ENG-SF20015-R1-Plat.pdf Markup Summary

SF-20-015
-18-20

FINAL PLAT
STERLING RANCH FILING NO. 2
JOB NO. 25188.01
05/24/2021
SHEET 1 OF 6

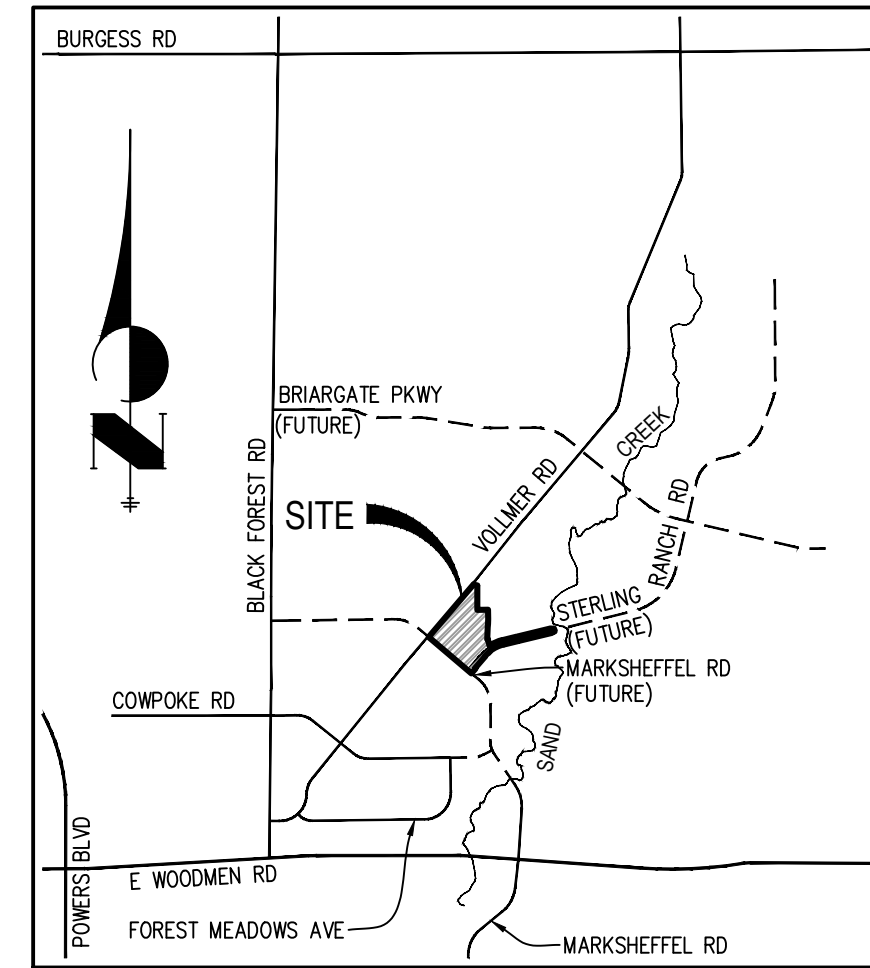
Add Colorado Springs acceptance of tract(s) or reference agreement.

Add Morley Bentley, Challenger and 8335 Vollmer Road signature blocks.

FINAL PLAT
STERLING RANCH FILING NO. 2
JOB NO. 25188.01
05/24/2021
SHEET 3 OF 6
FILE NO. SF-20-015

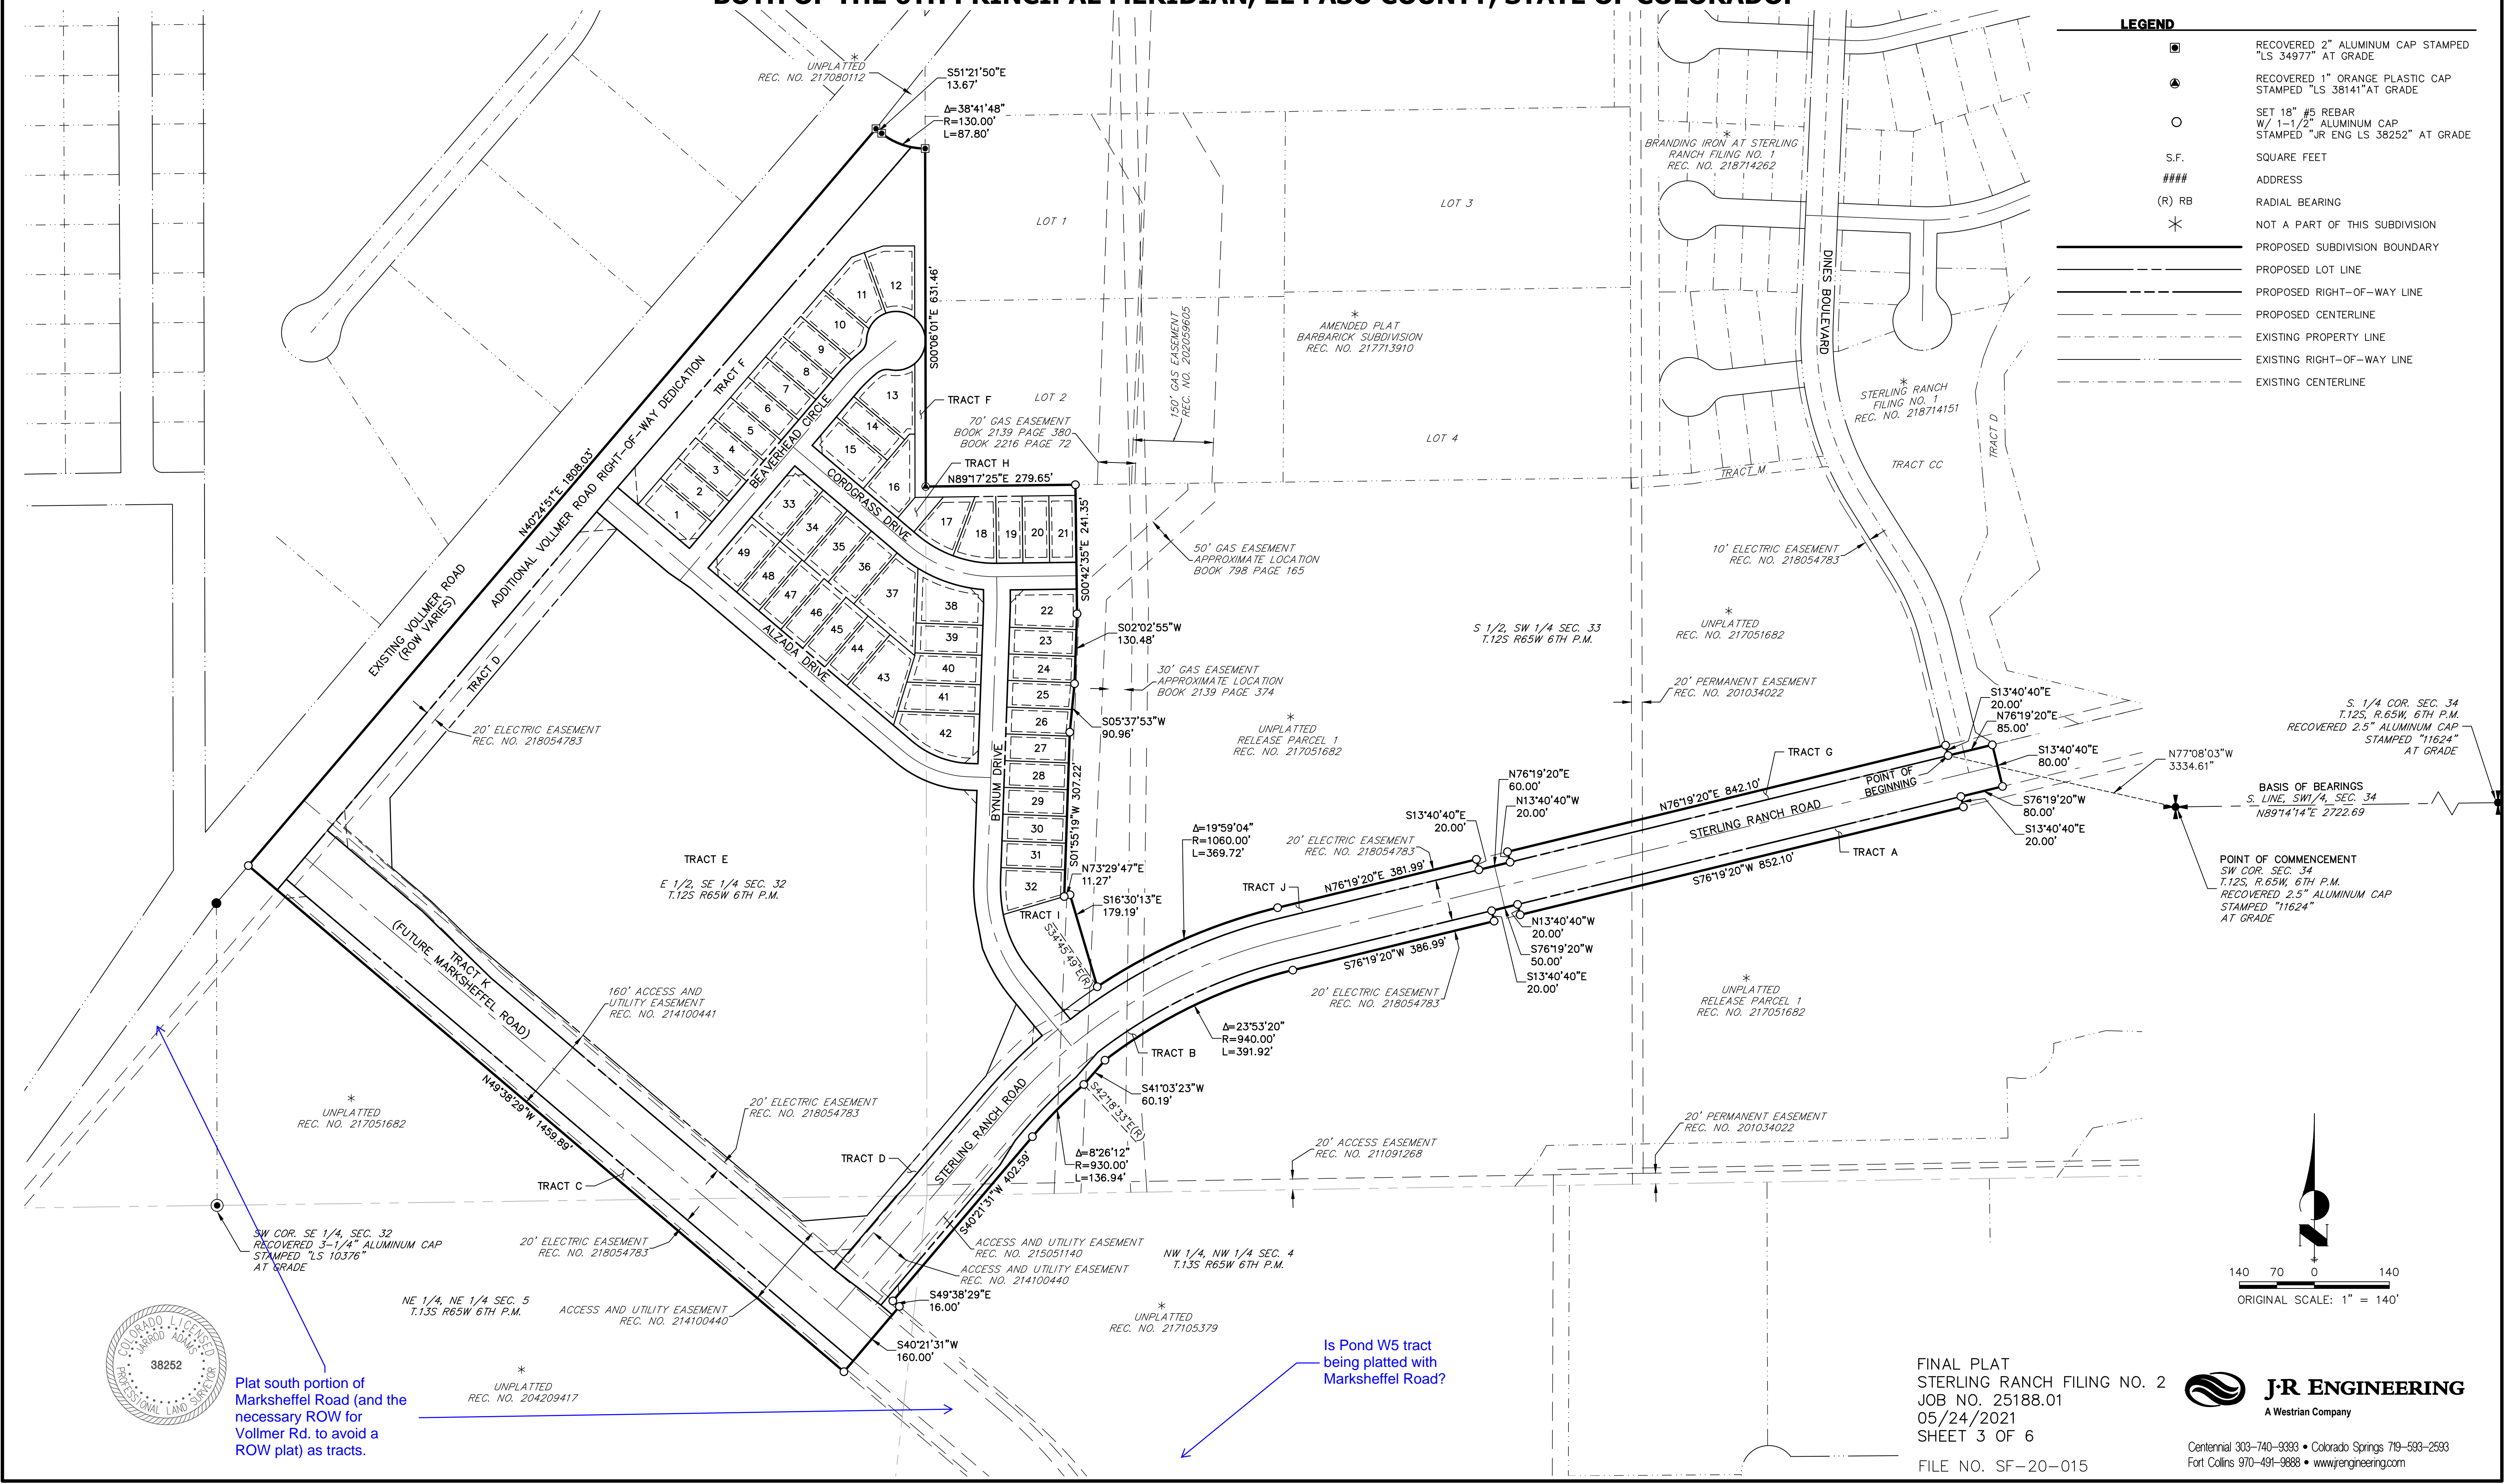
Plat Marksheffel Road as a tract.

Plat Marksheffel Road to south boundary as a tract.

Plat Pond W5 as a tract.

Plat Lift Station Site as a tract.

Plat as a tract or tracts.

FINAL PLAT
STERLING RANCH FILING NO. 2
JOB NO. 25188.01
05/24/2021
SHEET 5 OF 6
FILE NO. SF-20-015

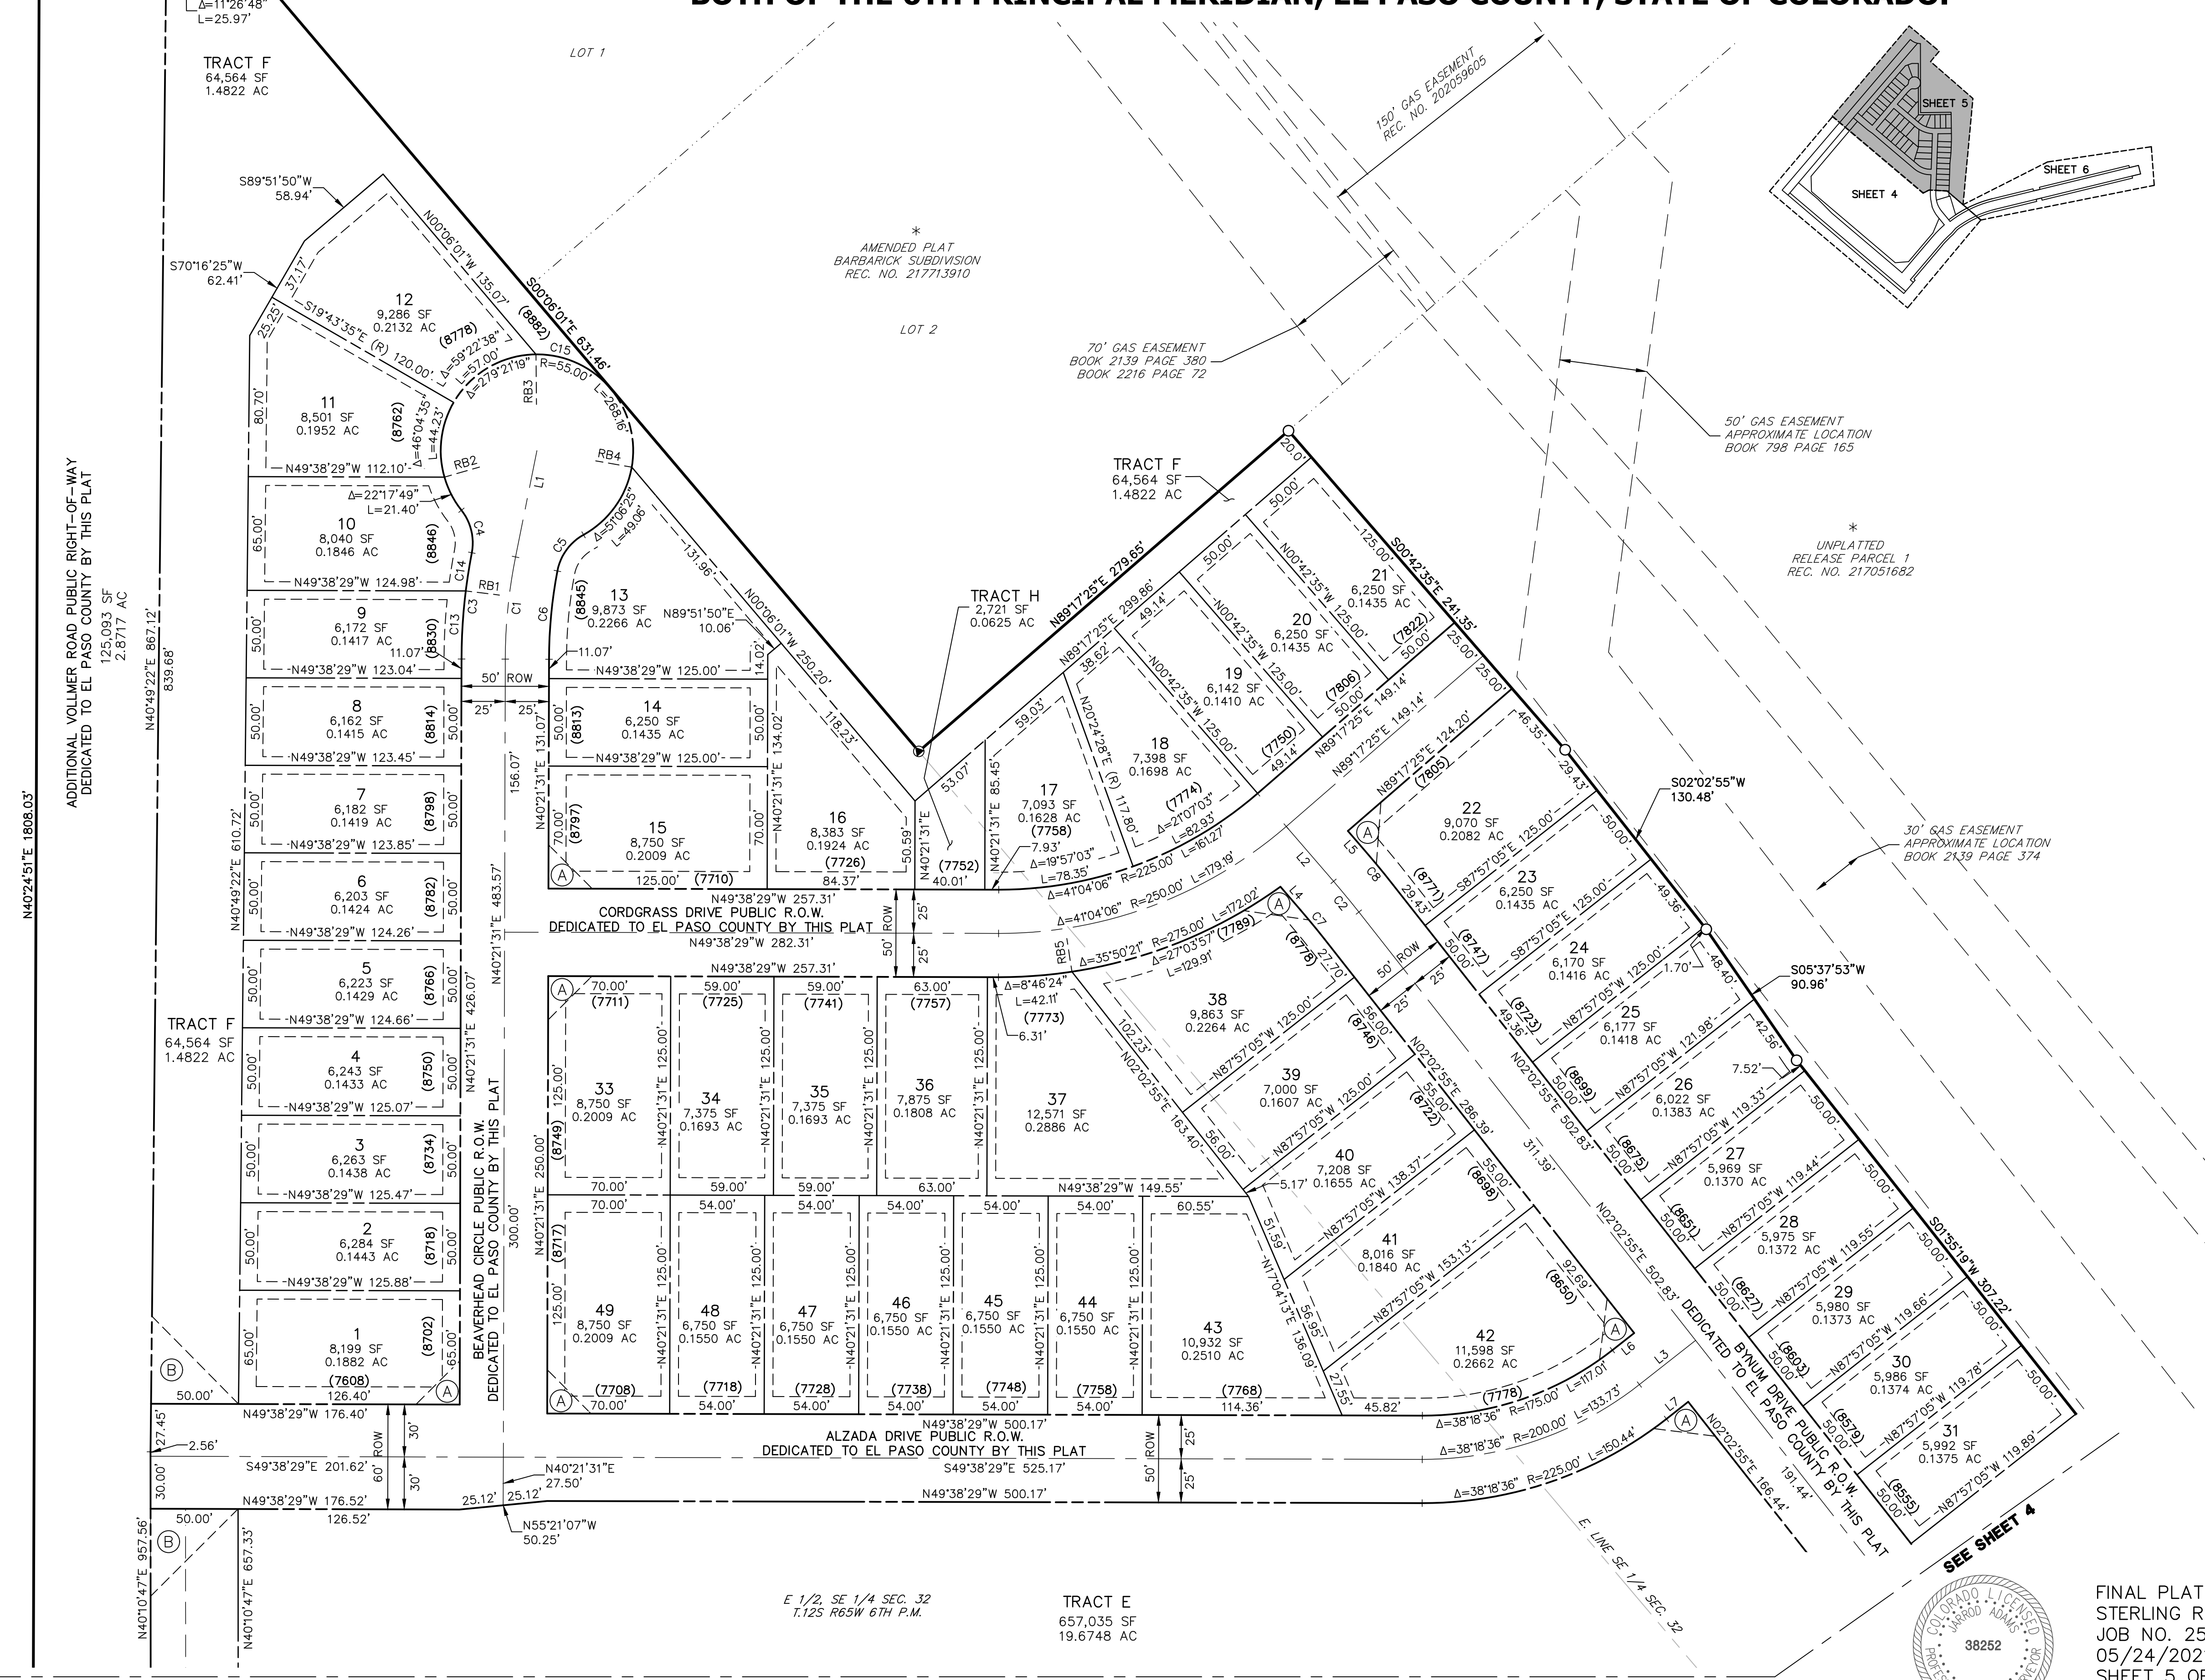
to be vacated
